# Sign Type: With pole covers in Place

# Sign Type: Without Poles Covers

Sign Type: With Covers in place

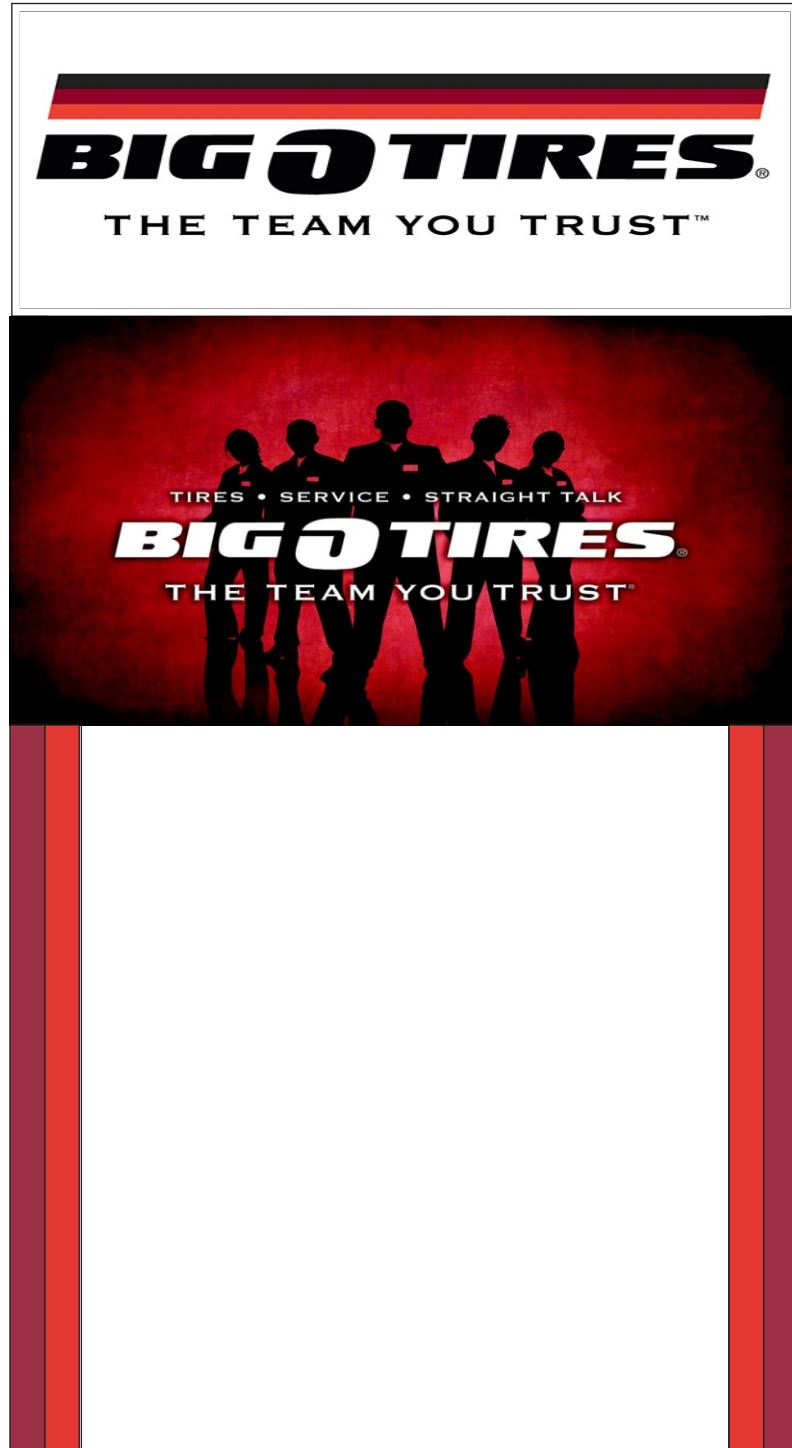
I need to see elevations of the structure showing height (the sign shall not be taller than the structure). I need to know if there is an attached sign on the same side that this sign is being proposed, and if there is an attached sign, I need to know the dimensions of that, in order to calculate the amount of sign area that is allowed with the 25% increase.

Which sign plan am I approving? The one with pole covers in place or the one without? Only resubmit the plan of the one that is going to be on the property.

what is the measurement here
